Rezoning Transportation Analysis

Petition Number: #2022-087

Date	Description
11-28-22	First Review (TM)
12-22-22	Second Review (DR)
1-23-23	Third Review (DR)

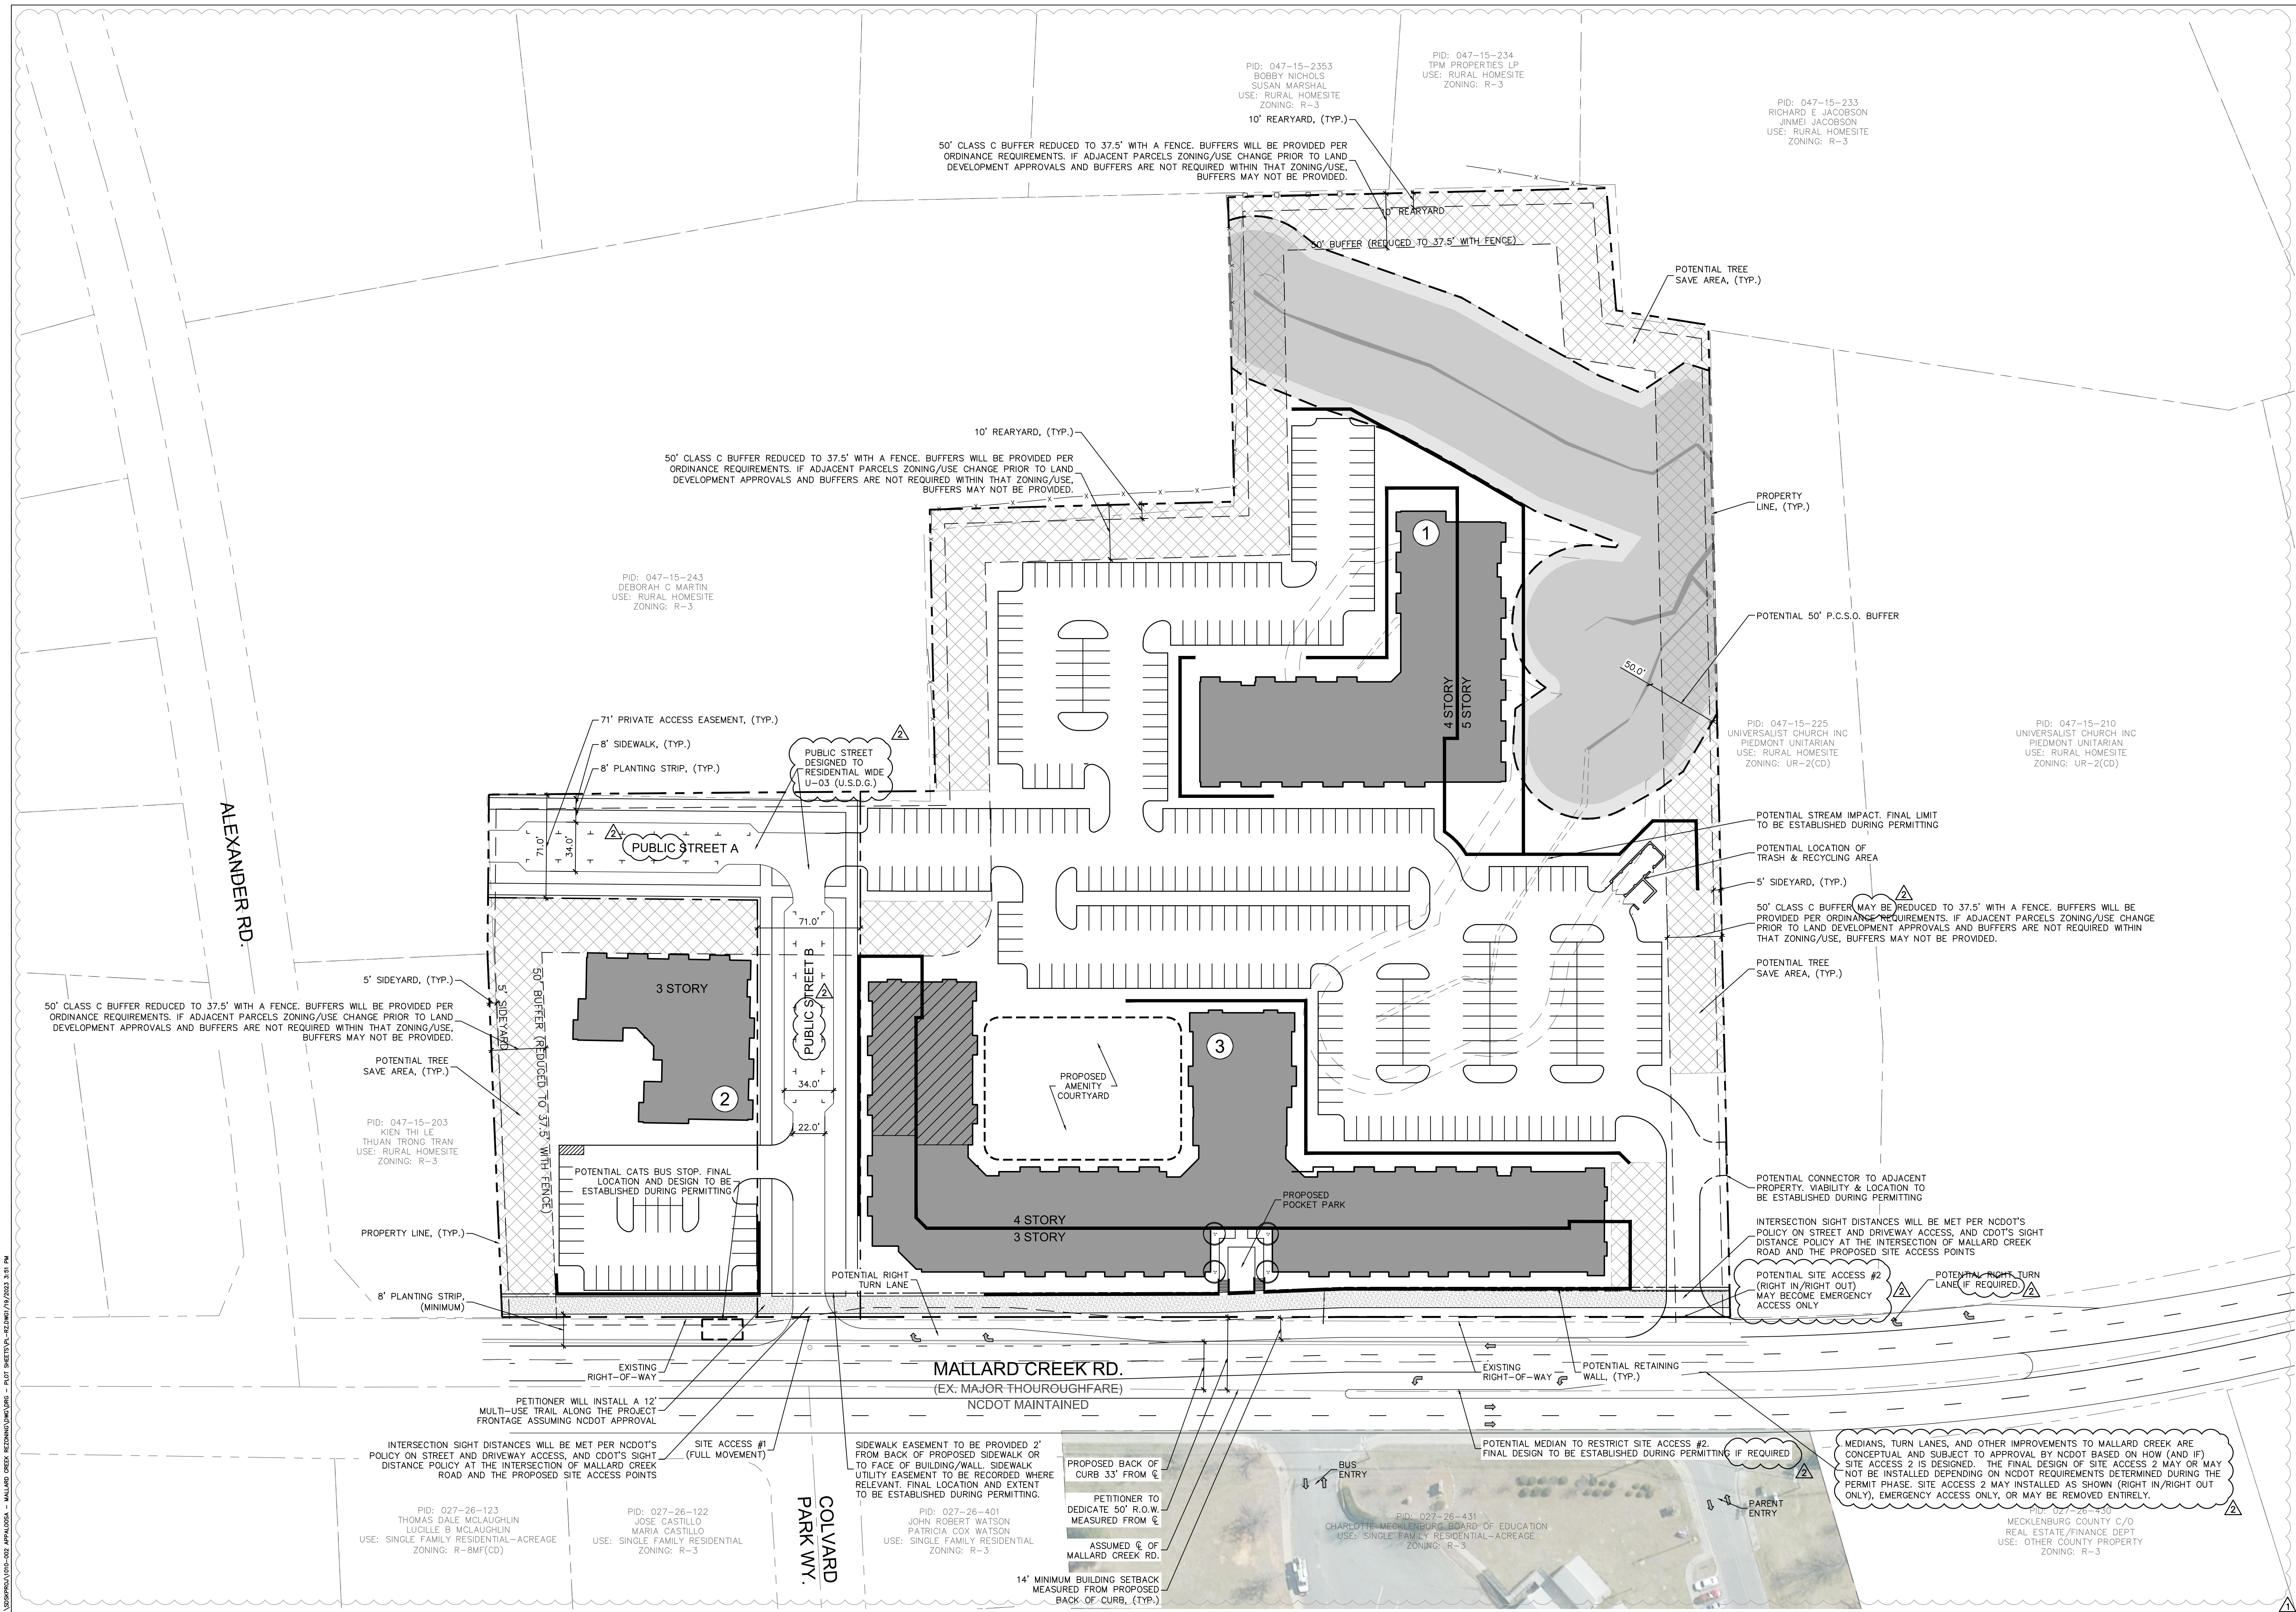
~~5. New comment from 12/22/2022: Modify median to ensure full movement for development adjacent can be retained from parcels 04715225 and 04715210. What is being proposed will create a change of access for the development adjacent to property.~~

~~13. **New comment from 12/22/2022:** Either remove conditional note or add as approved by NCDOT/CDOT at the end.~~

~~14. **New comment from 12/22/2022:** Remove word "potential" on callout for right turn lanes at site accesses. This is an NCDOT requirement. Add conditional note regarding right turn lanes at each site access. Label and dimension right turn lanes.~~

~~15. **New comment from 12/22/2022:** Remove "assuming NCDOT approval" on callout for 12 foot multi-use trail.~~
